Our Reference 60468641 23/1324/FUL Stone Barn

23/1324/FUL & 23/1325/LBC: Stone Barn, Dovecote Rise, South Rauceby

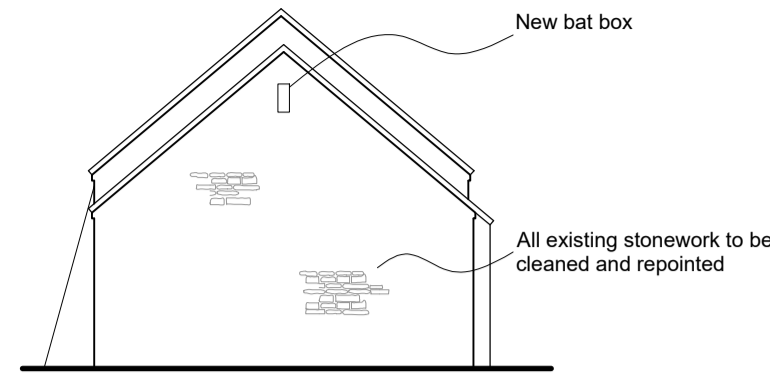
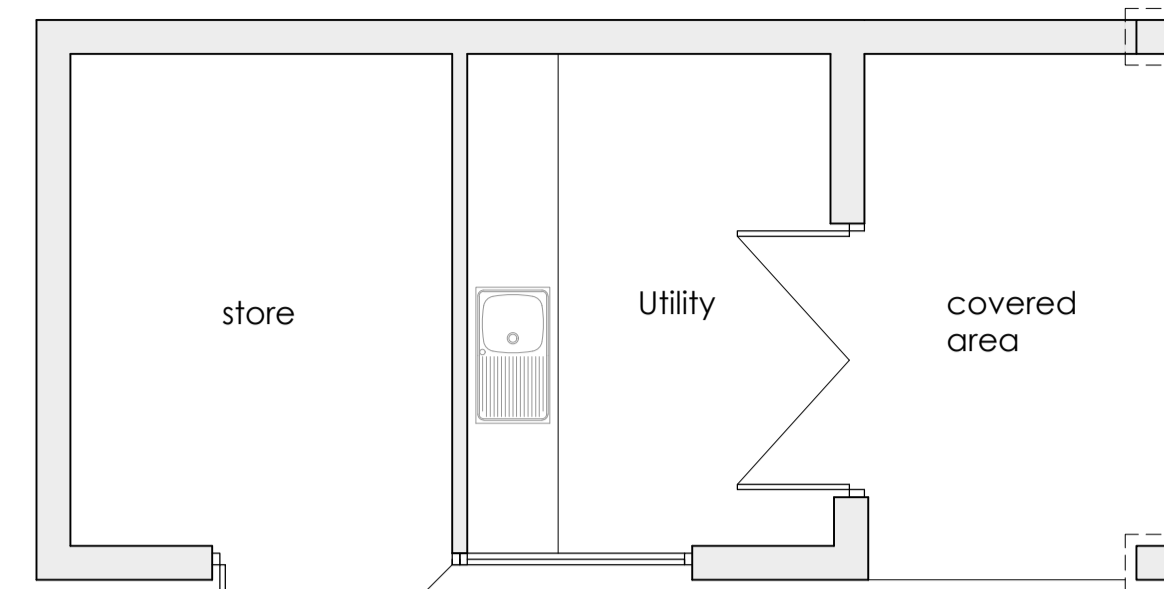
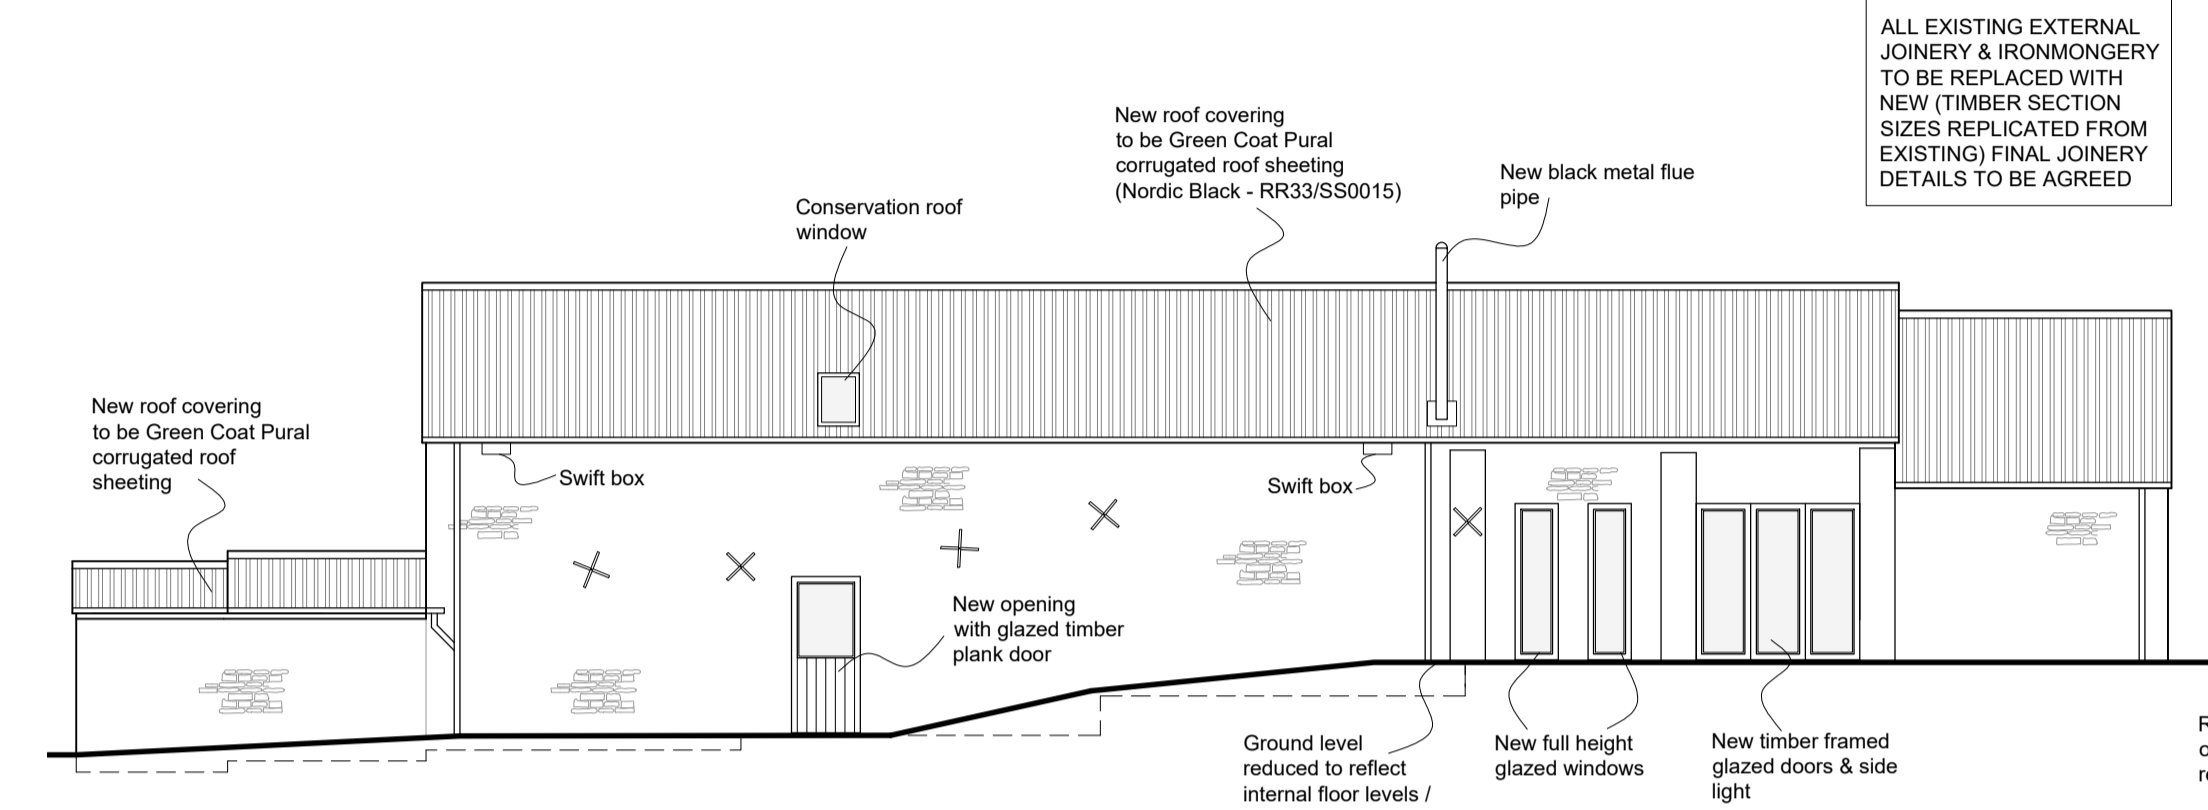
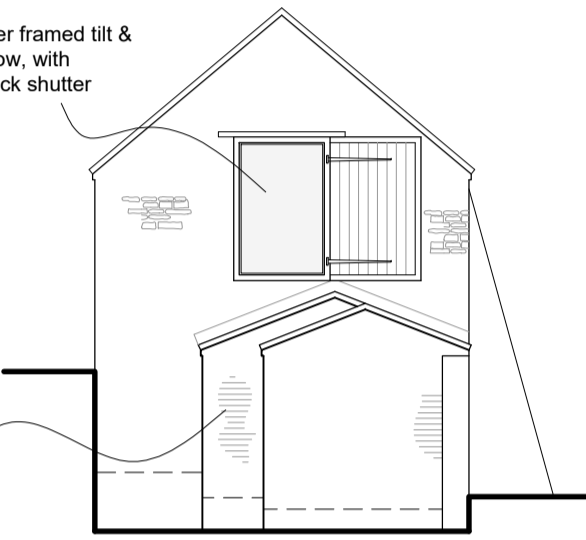
Proposals for ecological enhancement have been made in the form of one bat and two swift boxes and these are shown on the proposed layout plan. I welcome these proposals and these can be conditioned. However, I wish to give the following advice in relation to the proposals:

- I am not clear if the proposed boxes will be integral to the structure of the dwelling. The planning condition should secure integral provision.
- The proposed bat box is located on the north facing aspect. I think that the south facing aspect would be better (given it would be a warmer location) for a bat box, and this has relevance to the swift provision (see below).

- The swift boxes are proposed for the east facing aspect, but the positions are likely to be at a relatively low height and therefore sub-optimal for this species. I therefore recommend that these be relocated to the north facing aspect so that they can be positioned at above 5m height.
